Application by Associated British Ports for the Immingham Eastern Ro-Ro Terminal

The Examining Authority's further written questions and requests for information (ExQ3)

Issued on 01 December 2023

Image NTS1. Location of the proposed development

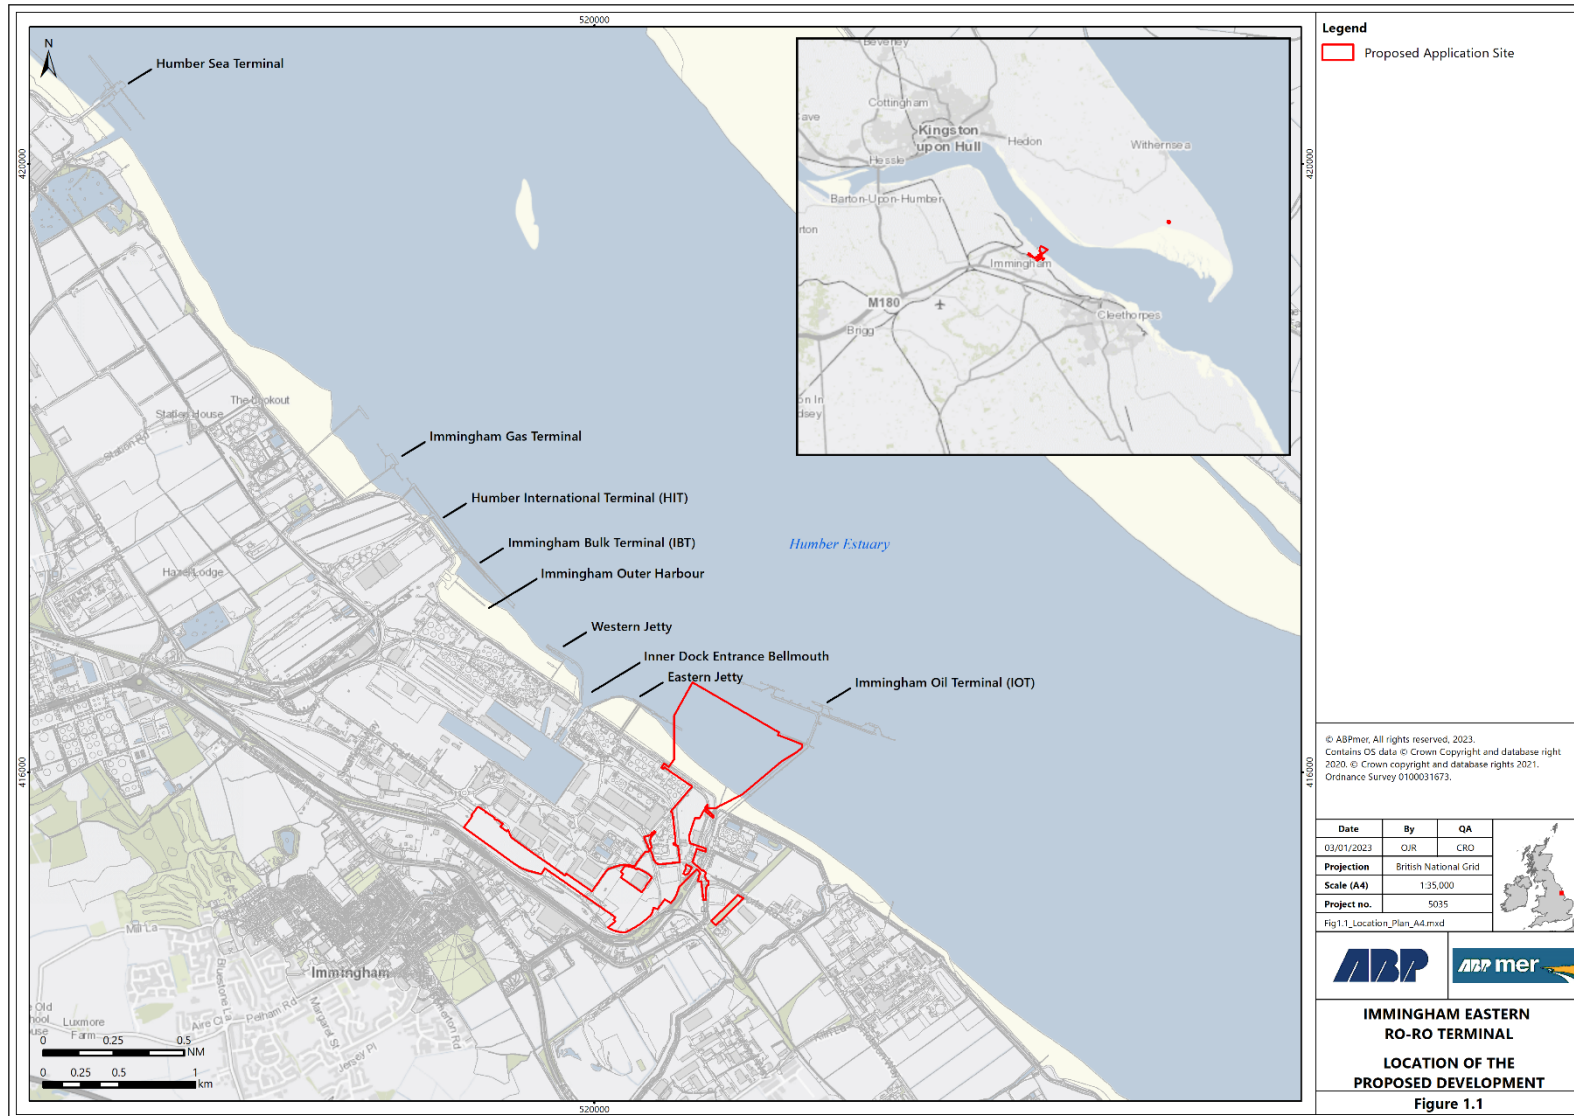
Question to:	Question
LHE Historic Environment including Marine Archaeology		
		No questions at this time.
BNE Biodiversity, Ecology and Natural Environment		
BNE3.01	Applicant	Image NTS1 of the Environmental Statement Non-Technical Summary [APP-035] needs updating, as the inset map appears to incorrectly show a red dot of the proposed application boundary on the northern bank of the River Humber.
		<i>No further questions at this time on this topic, as the Report on the Implications for European Sites questions are to be responded to by Deadline 7.</i>
